3 Palm Court Cottages,
South Strand,
East Preston,
BN16 1NZ

Re: EP/96/18/doc

I would like to oppose the planning application for the sewerage from the new properties built on the site of Tudor Lodge, Sea Road, East Preston to run into the present sewerage arrangements in Palm Court.

L2340-C-52-750 – Drainage for Planning

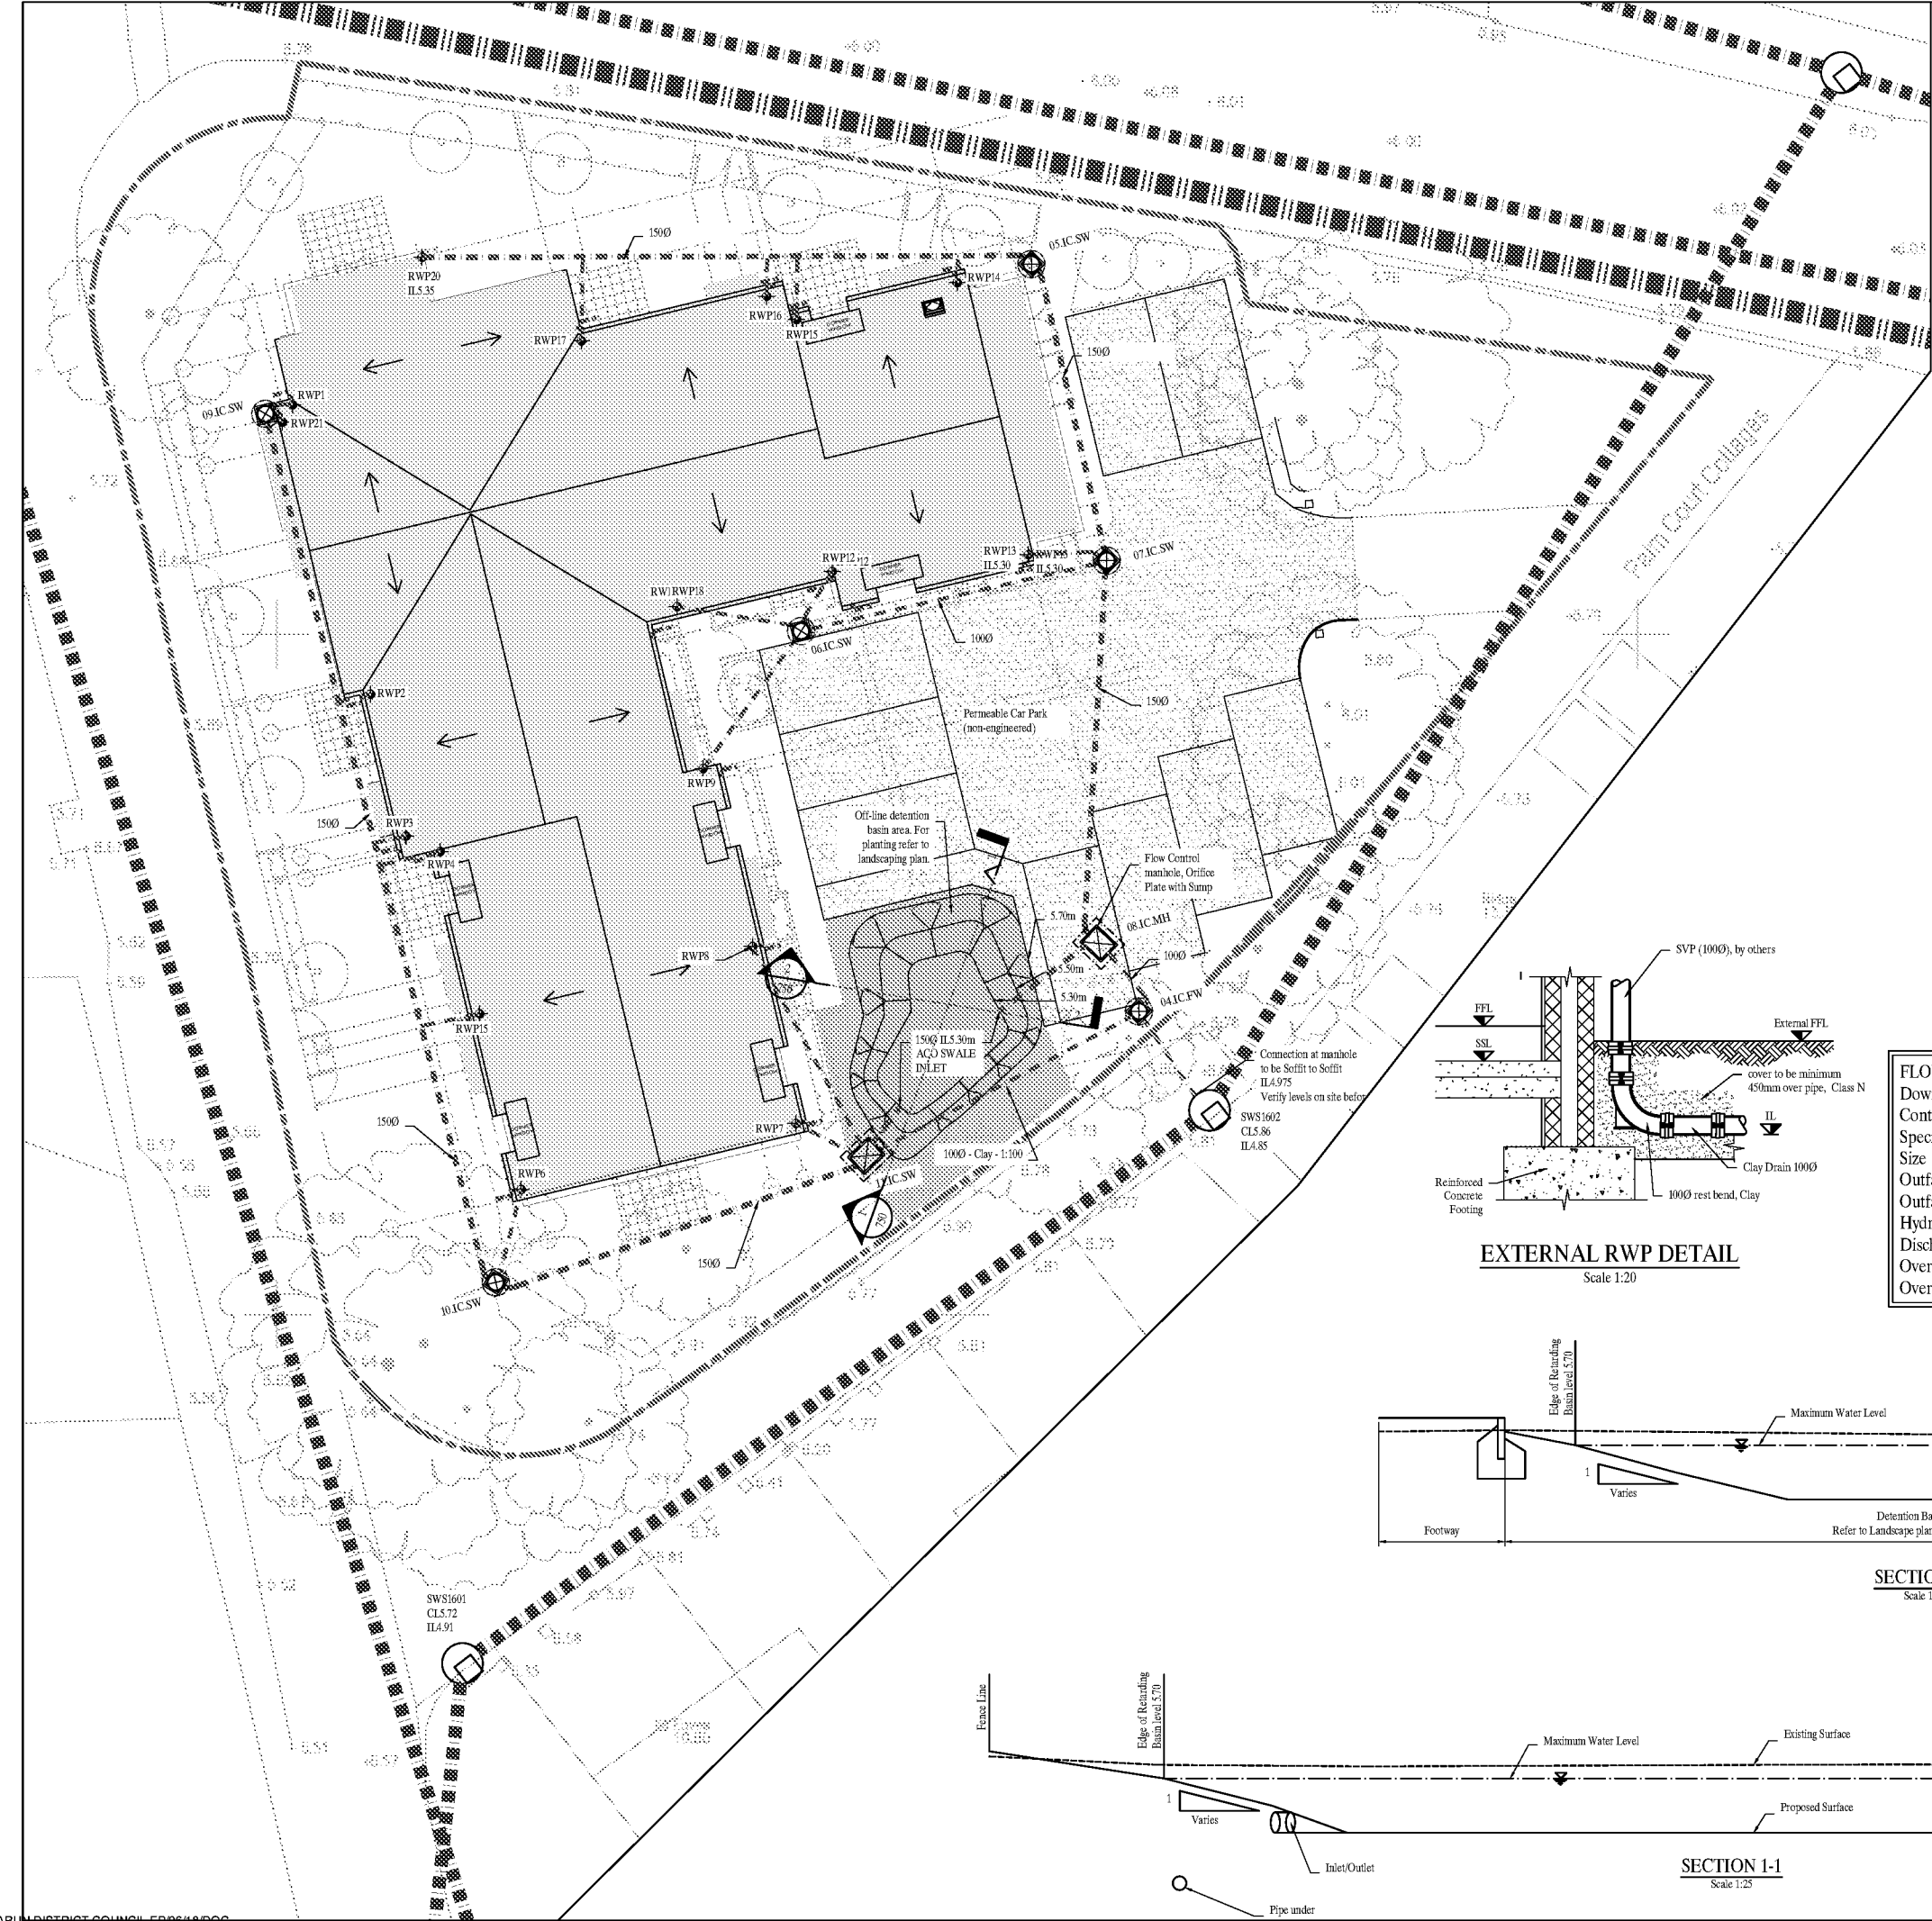
I with a neighbour on quite a few occasions have had to unblock the pipes using our own rods to stop and clear sewerage flooding into our gardens and when this has failed we have had to call Dynarod out. Our sewerage pipes are old and are used to their full capacity so we cannot afford to put any further strain on the system.
